**Re: Dogger Bank South Project – Written representation (deadline 6/12/25)**

I am writing again as an Interested Party (**20050002**) to provide further input regarding the Dogger Bank South Project in light of the Secretary of State's Information Request Letter (6 November 2025) — Dogger Bank South Project Unresolved Onshore Issues and Site Commencement, which invites comments on post-examination documents.

I am writing to draw your attention to outstanding, site-specific issues concerning the Burton Bushes Site of Special Scientific Interest (SSSI) and ancient woodland that were raised in my submission dated June 13, 2025, which, to my knowledge, have not yet received a substantive public response from the Applicants or the Examining Authority (ExA). My written representation of June 13, 2025, reinforced existing concerns shared by the Forestry Commission (FC) and introduced new questions regarding immediate threats to Burton Bushes.

DRAWING NUMBER: **PC2340-RHD-ON-ZZ-DR-Z-0586** PAGE NUMBER: **Page 2 of 5**

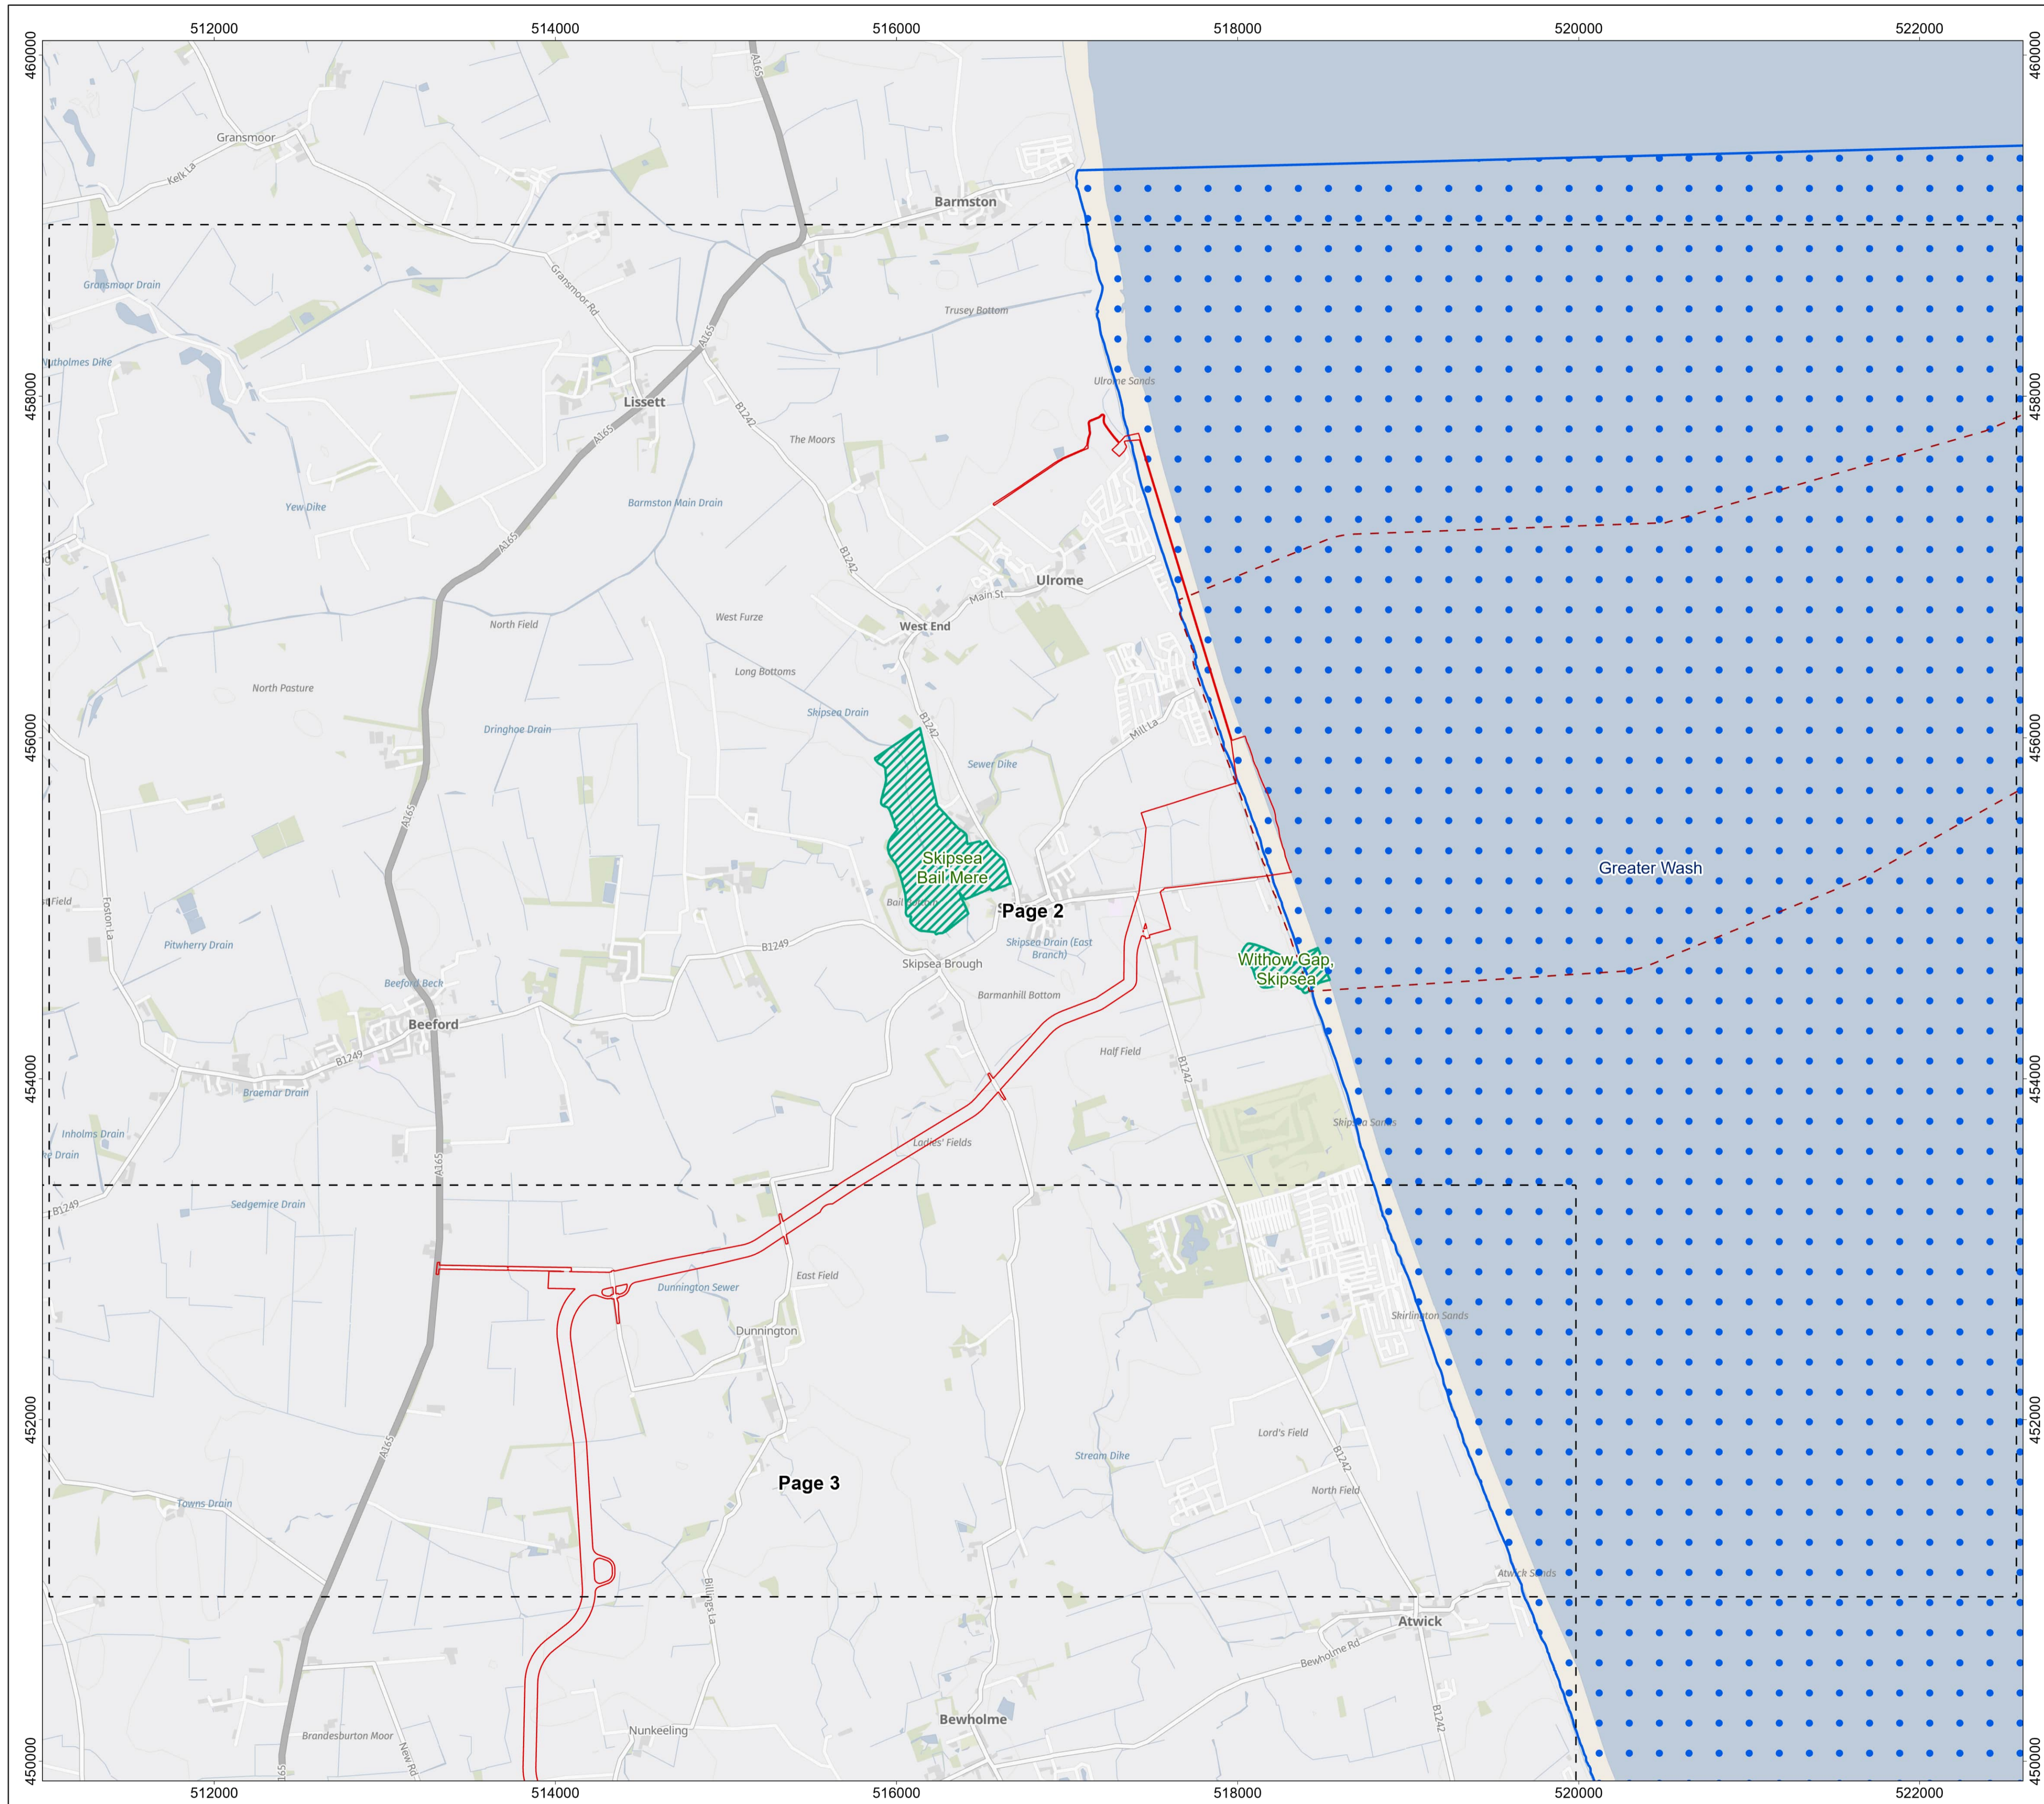
The most critical outstanding issue relates to land directly abutting Burton Bushes. I previously highlighted that the former Burton Gate House property, located immediately adjacent to Burton Bushes (0m distance), was recently sold and demolished, and subsequent preparation activities, including the erection of a fence, were observed. I requested confirmation from the Applicant as to whether this land was purchased and, if so, a thorough assessment of the potential impacts any proposed works, temporary compounds, or activities on this land would have on the adjacent ancient woodland and SSSI. I will note that new construction has already occurred on the other side of the road, which is likely temporary compounds, and quite regular traffic disruption is already happening (ahead of the actual decision..) These potential impacts include:

- Root Zone and Soil Disturbance from construction traffic or severance near the woodland boundary.
- Changes in Hydrology due to alteration of drainage patterns or interception of groundwater flow.
- Edge Effects arising from increased light, noise, dust, or chemical pollutants.

A comprehensive, transparent assessment addressing activities planned for newly prepared area so close to such a sensitive site, is in my opinion still lacking, and requires immediate reconsideration of the proposed buffer zone.

- Insufficient Buffer Zone: Both I and the FC noted the critical importance of protecting Burton Bushes as an irreplaceable natural resource. We highlighted that indirect impacts, such as dust and fugitive emissions from construction traffic, can cause deterioration of ancient woodland. While the standing advice recommends a

minimum 15m buffer, the FC could not find an assessment demonstrating that this distance would be sufficient against indirect effects. I maintain that the overland cable corridor, currently around a 100 to 125m gap, remains too close to Burton Bushes, and a 0.2km (200m) minimum buffer is necessary to mitigate these indirect and direct effects.

- Hydrological and Geological Assessment: Concerns were raised that hydrological changes resulting from nearby excavation, such as trench de-watering, may inadvertently drain or redirect water, potentially harming water-dependent habitats within the SSSI. The FC explicitly stated it was "not clear whether the potential impacts to the ancient woodlands and ancient/veteran trees, from the changes in hydrology as a result of the proposed works, have been assessed".

- Trenchless Crossing Commitment: The Applicant's commitment to use trenchless crossing techniques at depths greater than 5m, unless clear evidence demonstrates a shallower depth would not cause adverse impacts, was critically reviewed by the FC. The FC explicitly stated it is "not clear how geotechnical investigation could provide clear evidence" to justify a shallower depth without risking impacts to roots, soils or rhizosphere, emphasizing that such investigations "may not be sufficient to ensure that no impacts would occur to biological and organic processes".
